Application for a non-material amendment following a grant of planning permission.

Number	<input type="text"/>
Suffix	<input type="text"/>
Property name	<input type="text" value="2 & 4 Steeplands"/>
Address line 1	<input type="text" value="2 & 4 Steeplands and 1 & 3 Claybury"/>
Address line 2	<input type="text"/>
Address line 3	<input type="text"/>
Town/city	<input type="text" value="Bushey"/>
Postcode	<input type="text" value="WD23 1BT"/>
Description of site location must be completed if postcode is not known:	
Easting (x)	<input type="text" value="513819"/>
Northing (y)	<input type="text" value="194800"/>
Description	<input type="text"/>

The proposals are for a new build development to include 24 flats within 3 blocks over part 3 and part 4 storeys with associated car parking proposed at new basement level.

Reference number:	<input type="text" value="Ref 16/0127/FUL"/>
Date of decision	<input type="text" value="29/06/2017"/>

**1 Side Elevation 2 - Block B**  
1 : 100

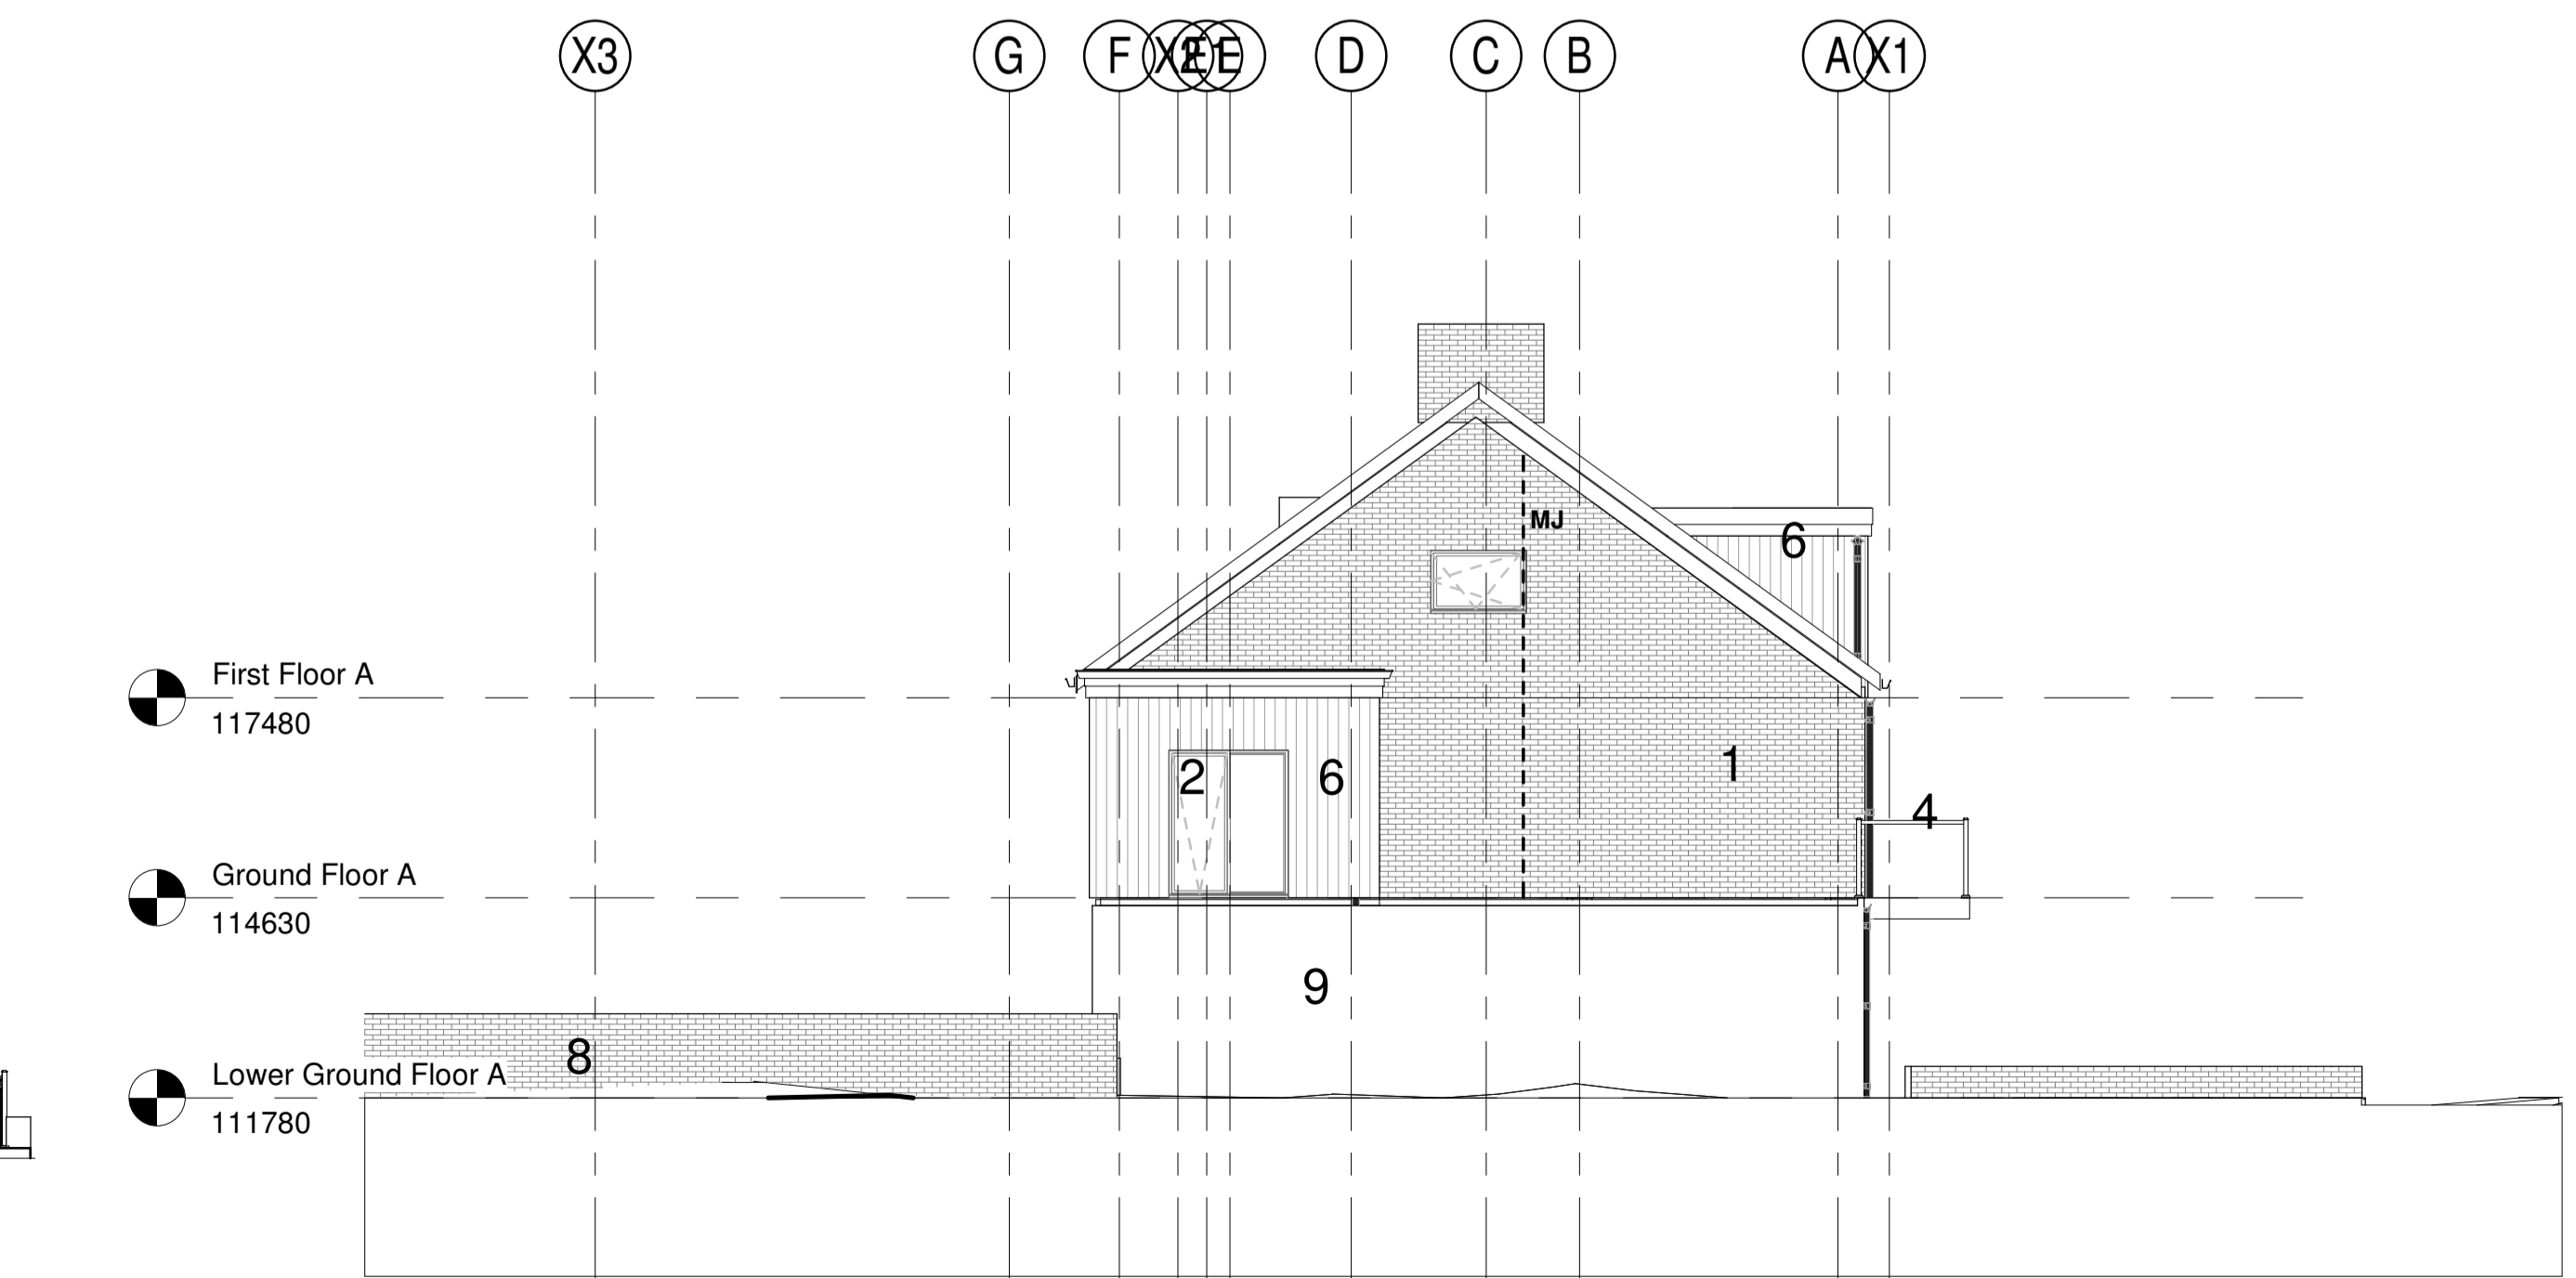
This application seeks to change the window material from timber to aluminium.

Current market conditions have resulted in excessively long procurement times for timber windows which cannot be accommodated within the construction programme for the development. Therefore we are proposing aluminium windows instead of timber, which will match with other aluminium elements that are already part of the scheme (curtain walling, balcony cladding, balustrade handrails).
